## **SOUTH EAST ANGLIA LINK (SEA LINK) PROJECT (EN020026) – DEADLINE 2 SUBMISSION**

As raised at the Preliminary Meeting, National Highways' review of the Transport Assessment (6.3.2.7.A ES Appendix 2.7.A Transport Assessment Note, document APP-122) highlighted an issue of concern to National Highways.

**Plate 7.1 Forecast peak daily trips between the study area and SRN**

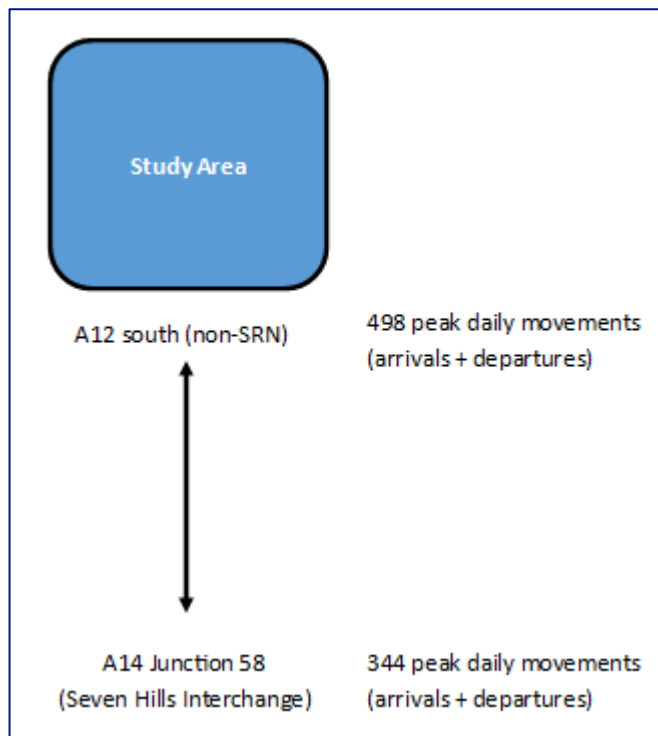
The Applicant concludes in paragraph 7.3.9 that the Seven Hills Interchange does not need to be modelled as the large increases in traffic are expected to fall outside the peak hours (08.00-09.00 and 17.00-18.00). Further, the TA notes (in paragraph 7.3.11) that, “since the trips on the SRN are less than on the LRN and as the effects on the LRN are shown to be not significant there will be no significant impacts on the SRN”.

Notwithstanding these points, National Highways seeks further, evidenced assurance from the Applicant that the SRN in this location will not be adversely impacted by construction traffic arising from the development. The interchange is already congested and an increase in movements of approximately 100 vehicles, even in the peak shoulders, could be material. The Applicant is also asked to consider the cumulative impact at the junction, with other planned developments in this location and the proposals for a significant highway improvement of the A12, which would include amendments to the junction, and could be built to a similar timescale as the development. The A12 scheme is being promoted by Suffolk County Council and is currently at the consultation stage of a planning application.
